SUBJECT: RIO GRANDE HOUSING
2334 Rio Grande Blvd NW
Site Plan for Building Permit
Project 1009204

Submitted herewith in support of final signoff by DRB is one copy of the Site Plan for Building Permit, revised to address EPC conditions of approval, as outlined in the Official Notification of Decision, dated May, 10, 2012.

A5 BUILDING LIGHTING

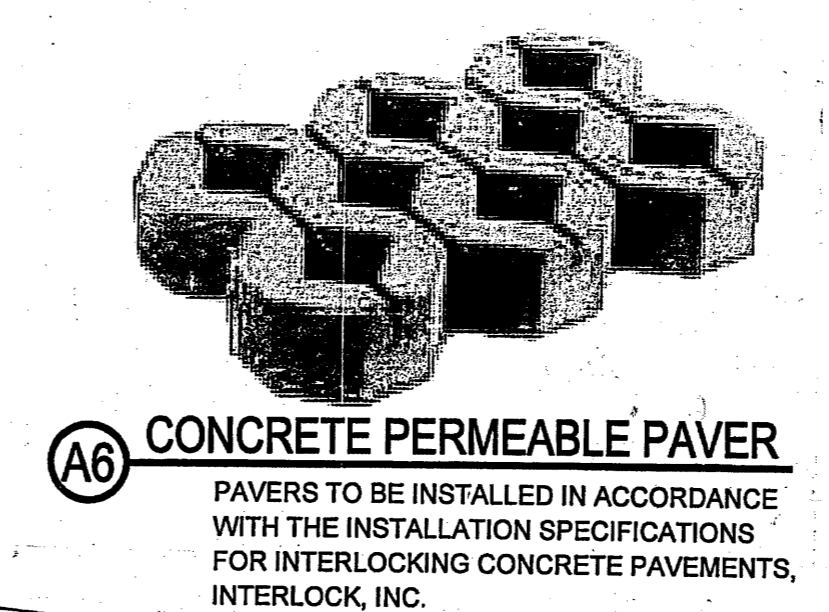
6. Building mounted light fixtures are to be shielded per the detail provided.
7. The Landscape Plan has been revised to show mature size of landscaping, square footage of the landscaping in the courtyard area, and required number of street trees.

A1 SITE DEVELOPMENT PLAN FOR BUILDING PERMIT
SCALE: 1" = 20'

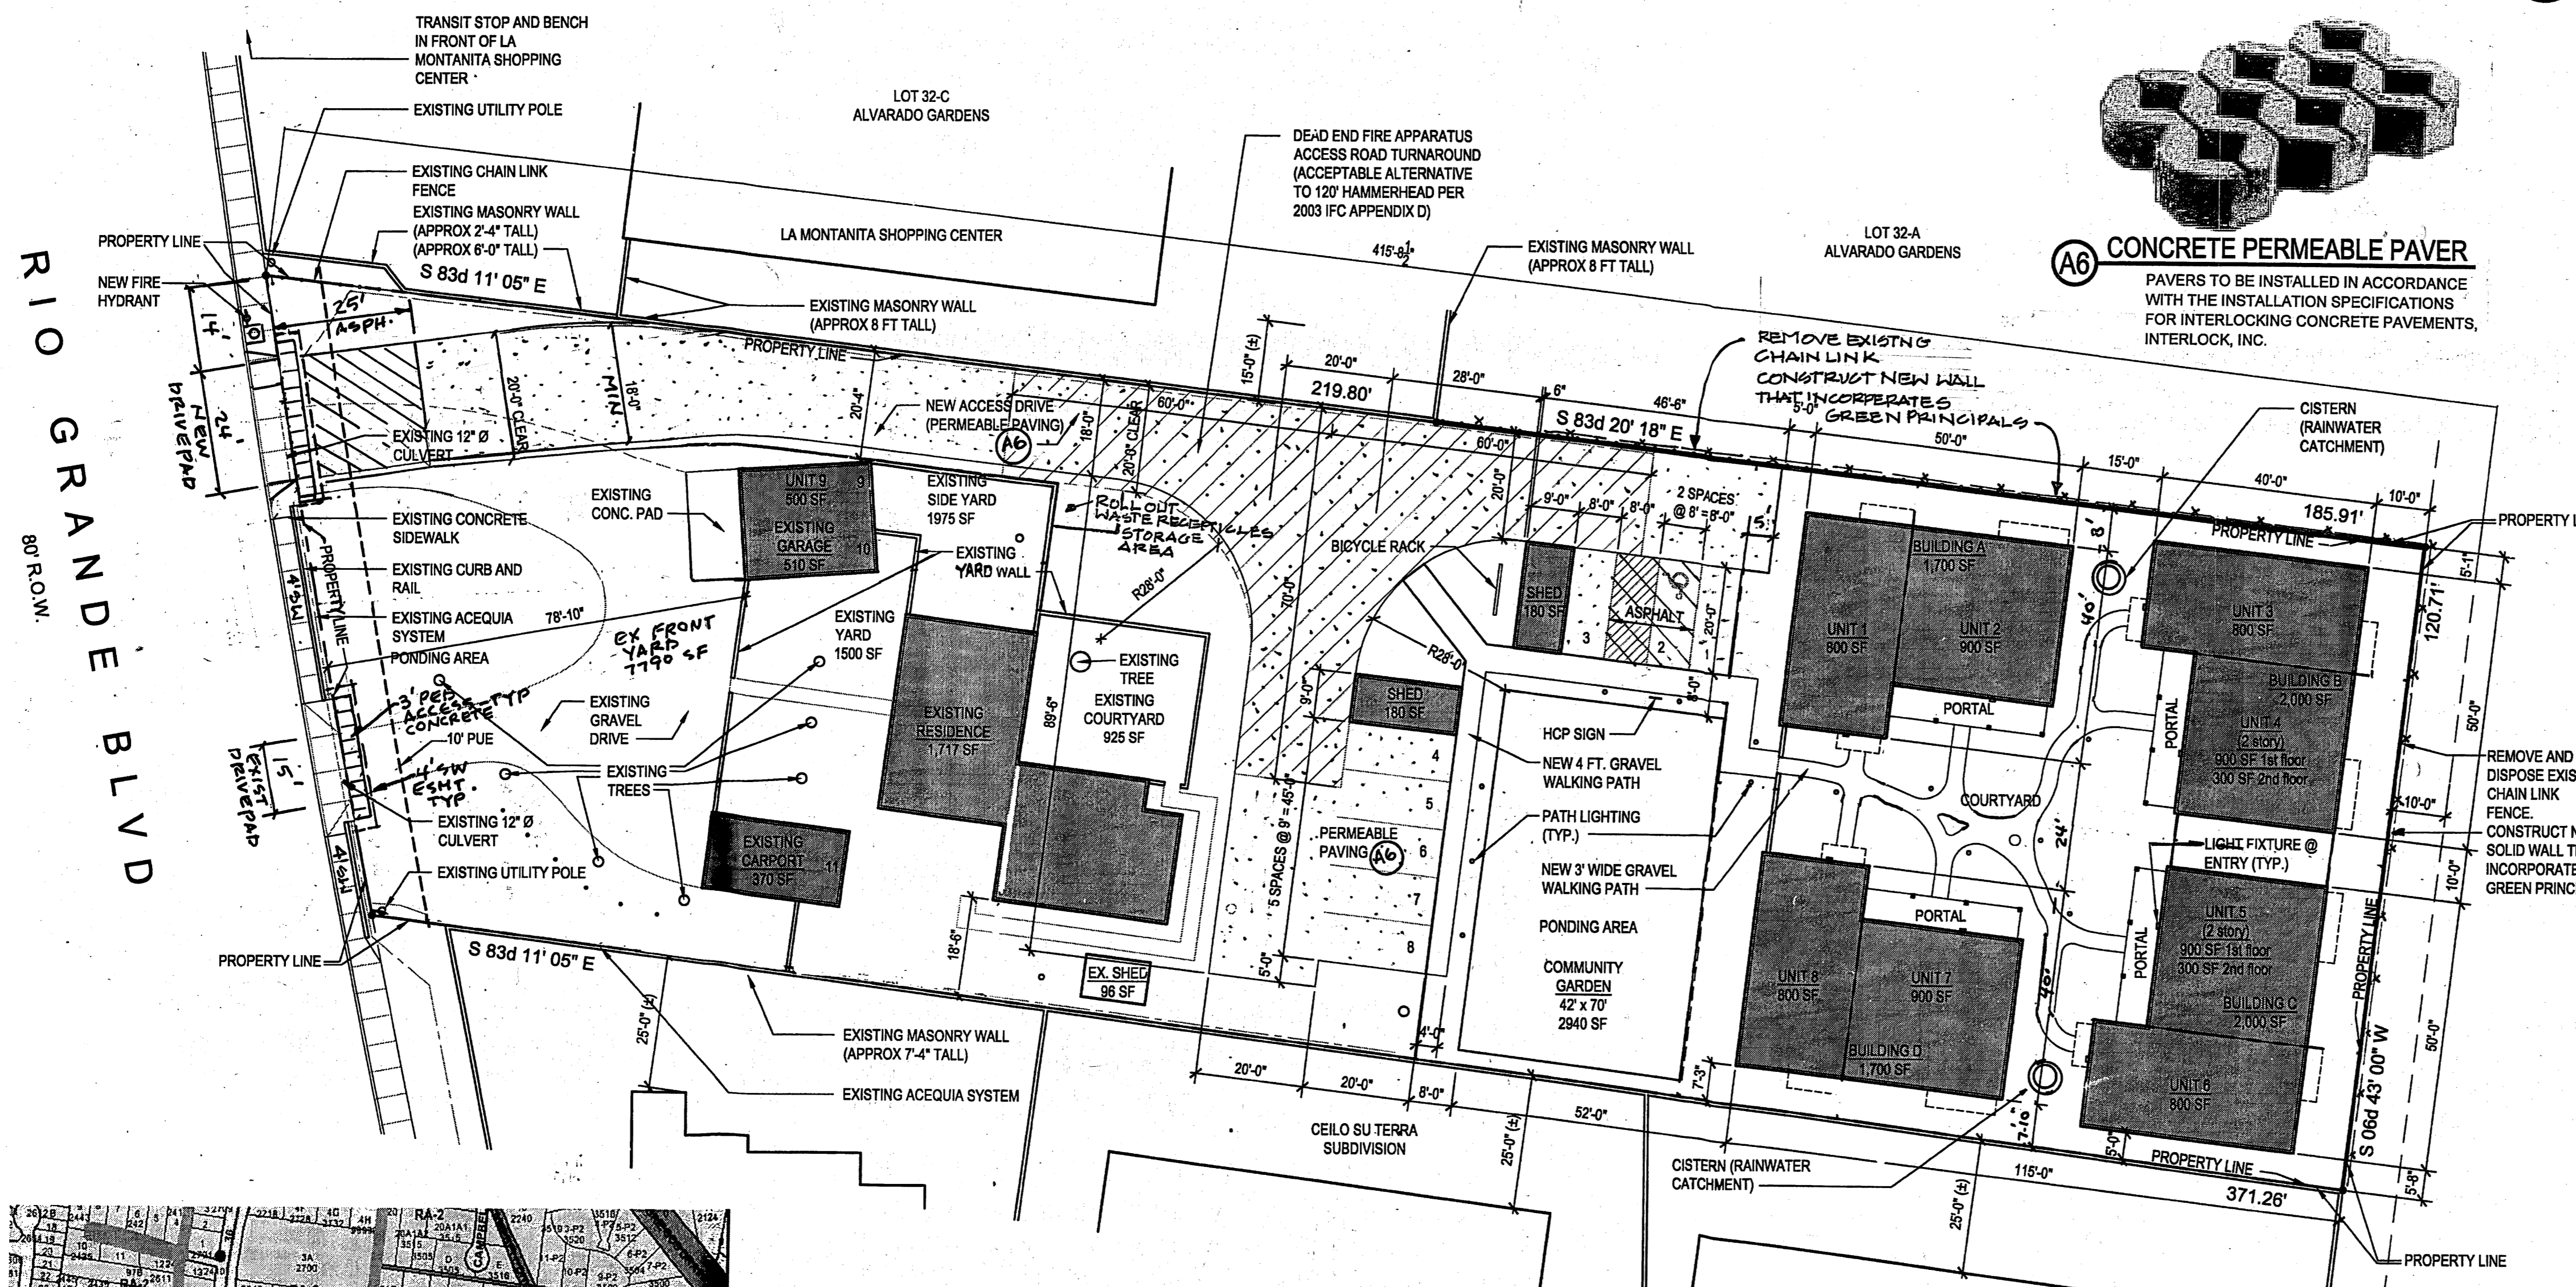
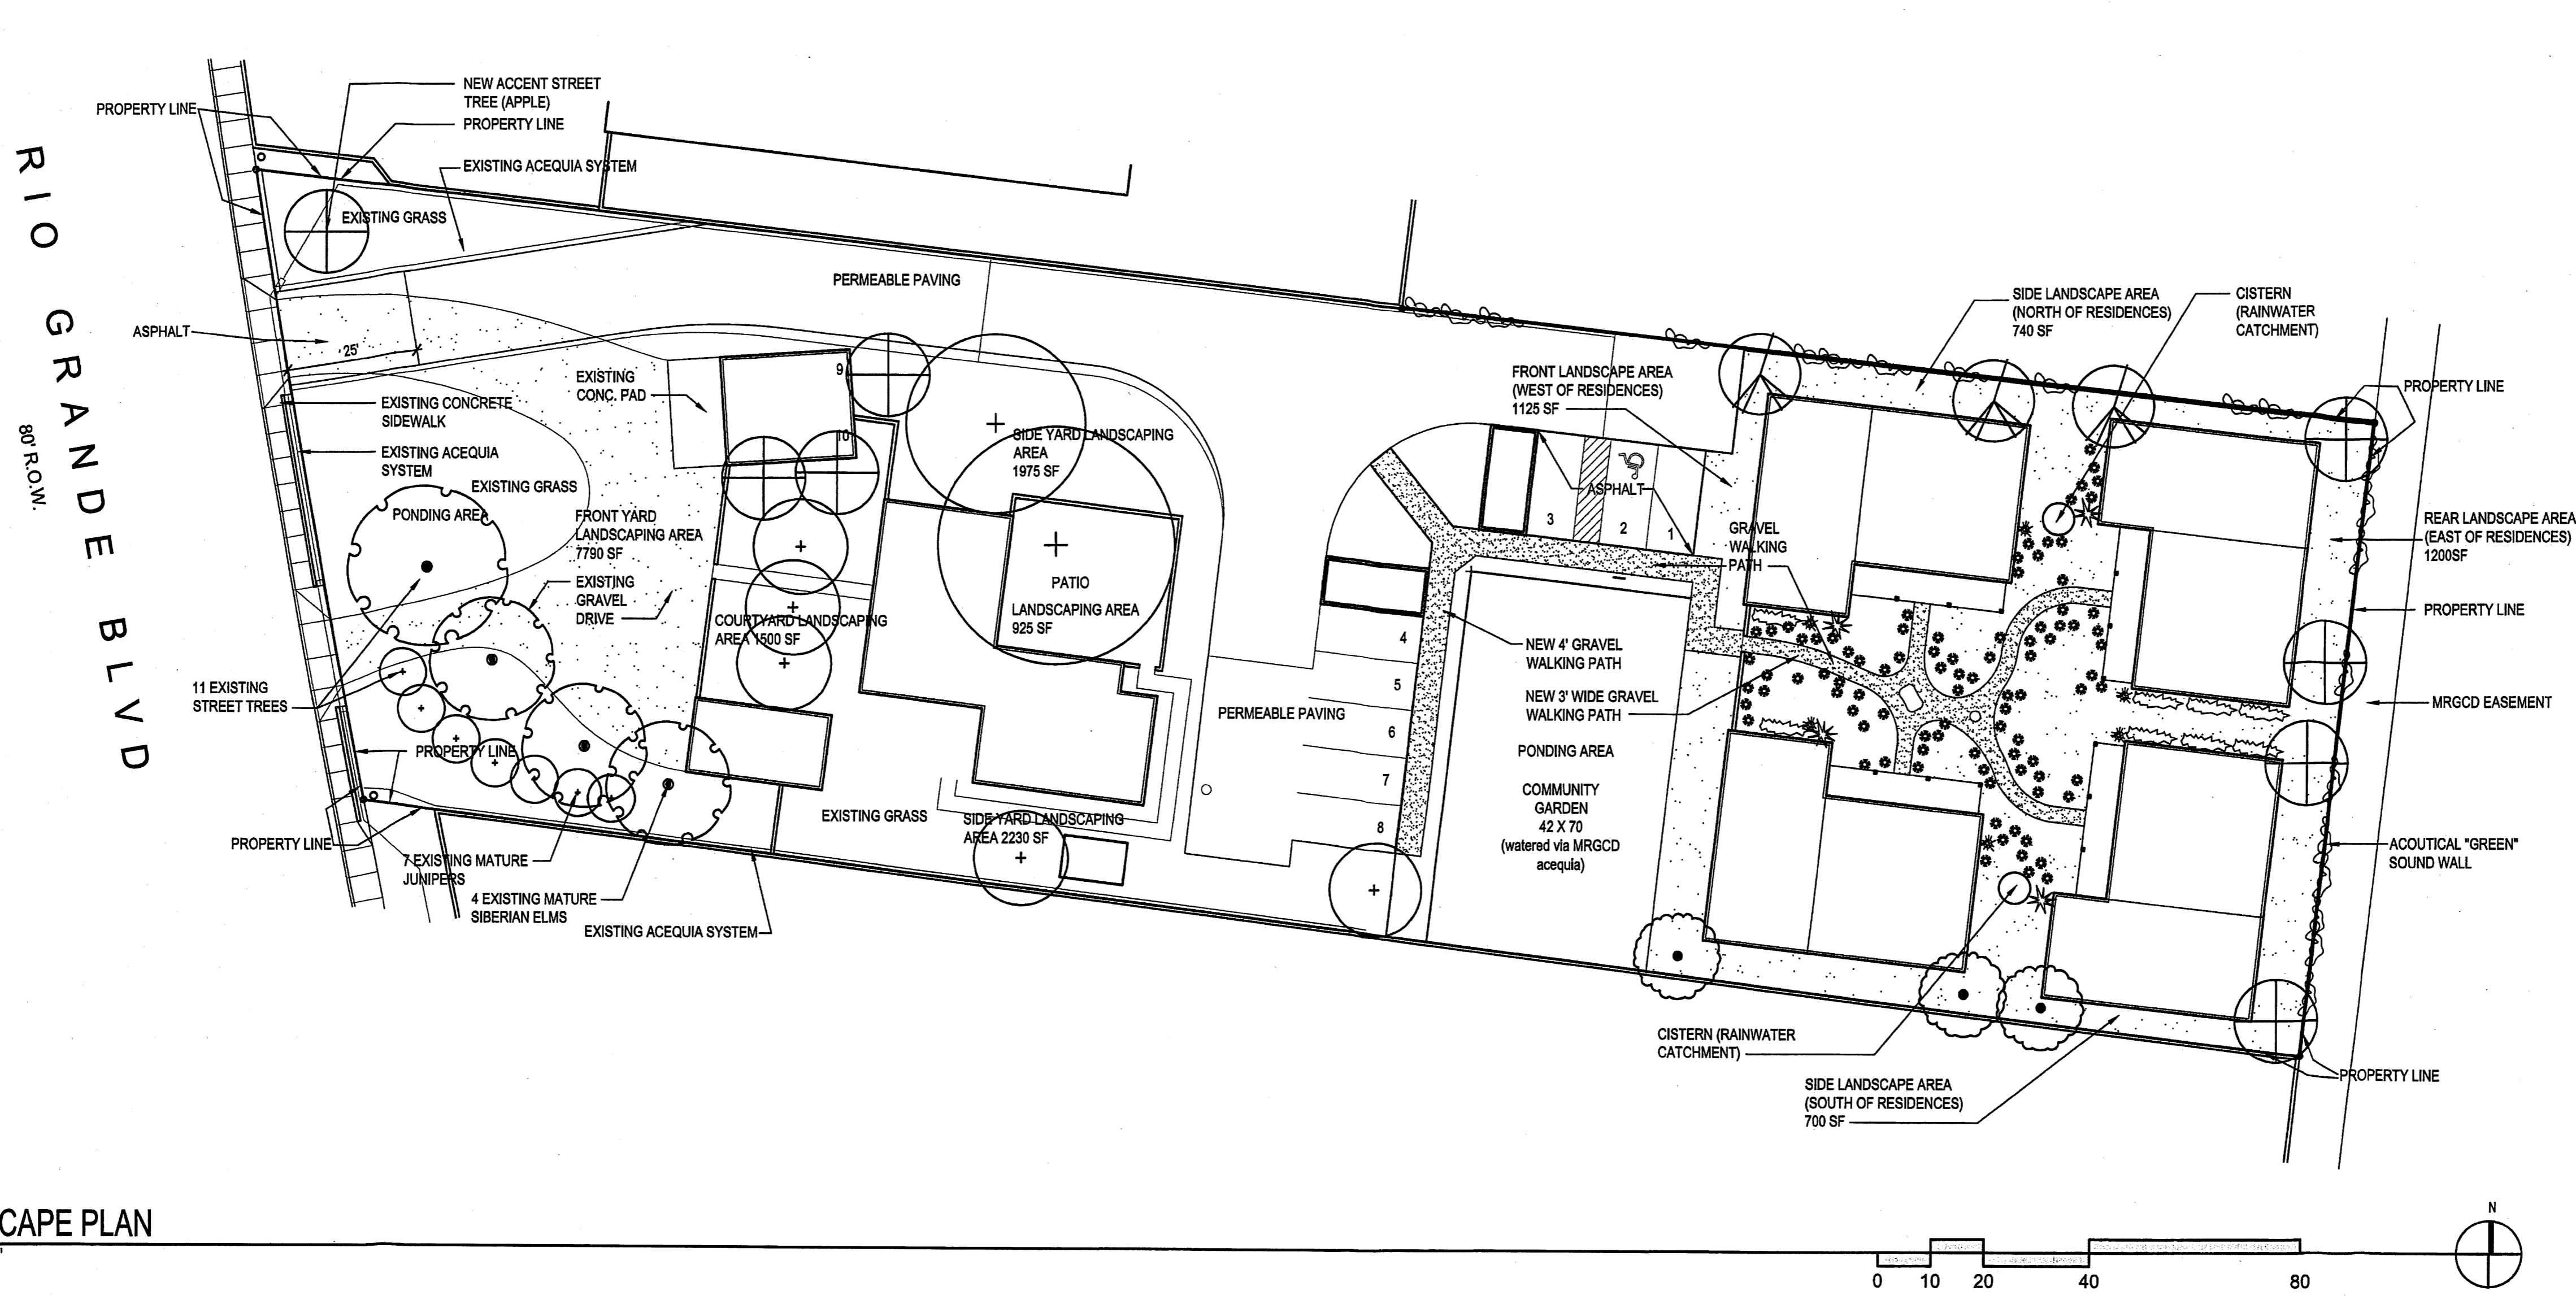
4. Solid Waste has signed the site plan and a note has been placed on the plan indicating how solid waste will be handled.
5. The callout "base course and crushed rock" has been changed to "permeable paving". The limits of paving have been illustrated with hatch patterns.

- b. ADA parking will be surfaced with asphalt pavement and the accessible isle is 8 feet wide.
 - c. The project entrance is recommended to be 36-40 feet wide. The driveway entrance is to remain 25 feet wide. Per condition #13, EPC supports a variance to the entrance width in order to maintain the existing width.

- d. The new access drive is surfaced with asphalt pavement for the first 25 feet from the existing sidewalk.

B1 LANDSCAPE PLAN
SCALE: 1" = 20'

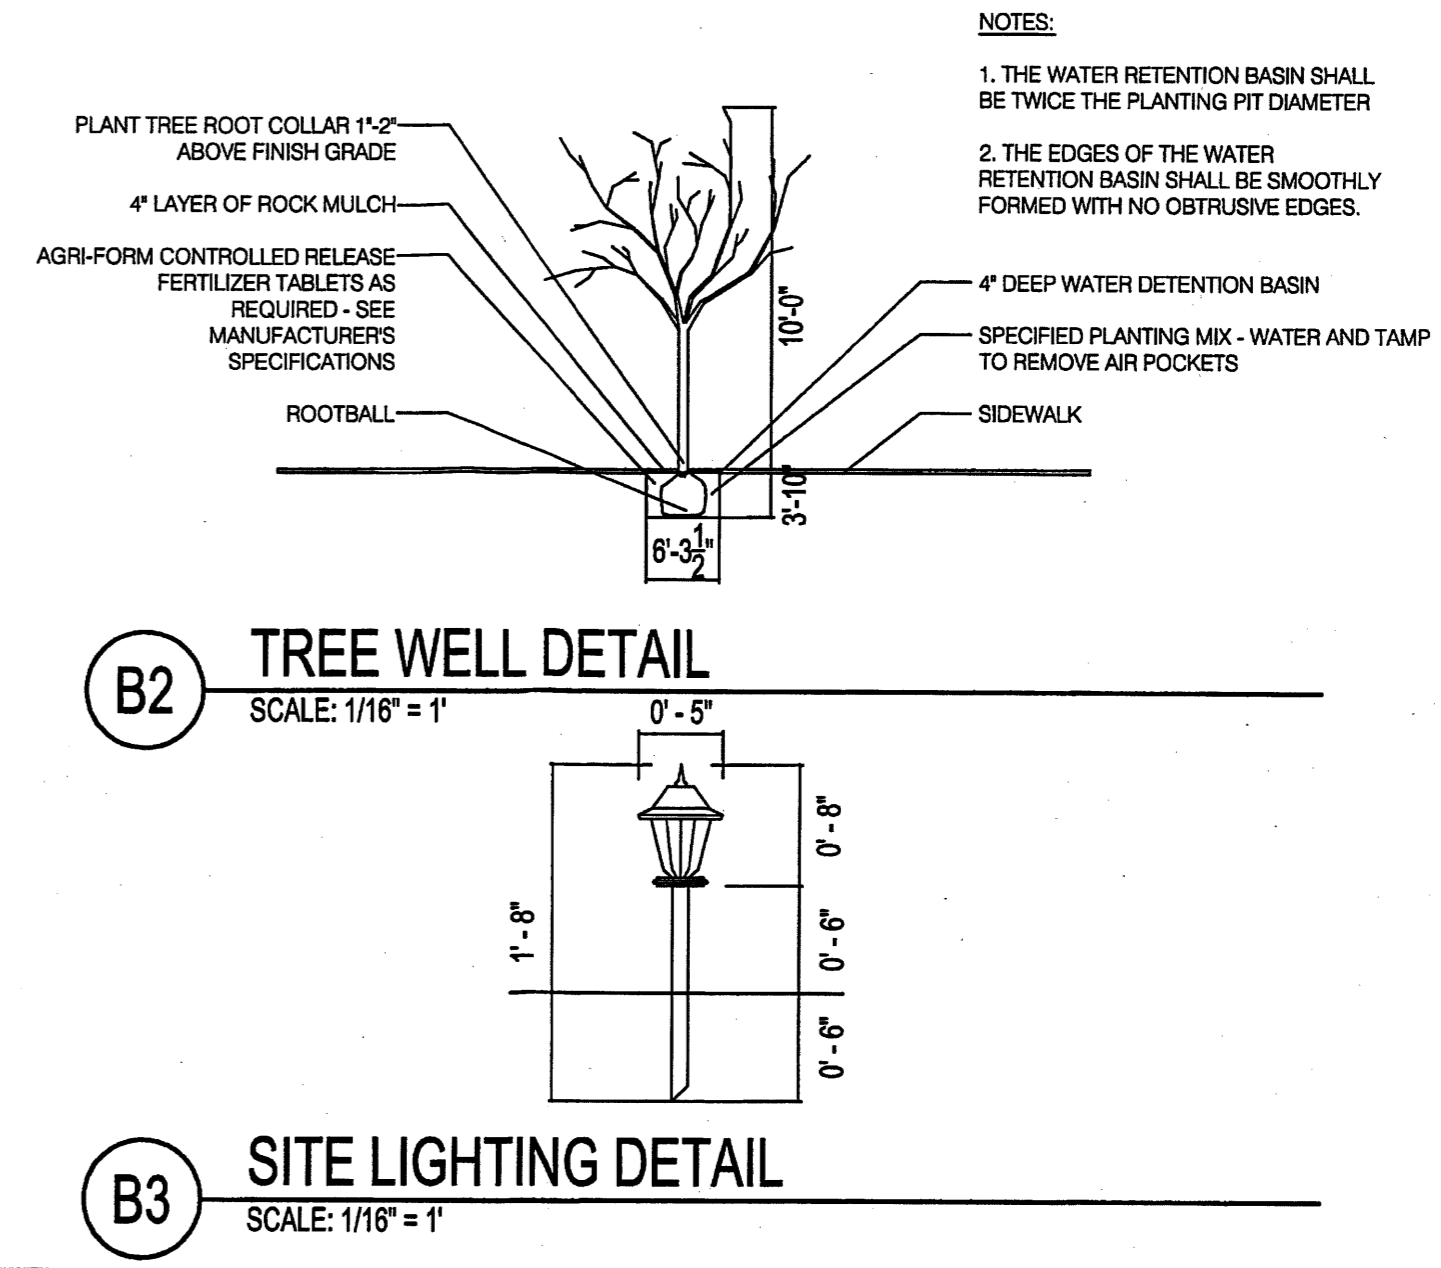
11. The landscaping shown on the Landscaping Plan matches the Landscaping Legend.
 12. The maximum building height of 24 feet to the top of the pitch is noted on the building elevations.
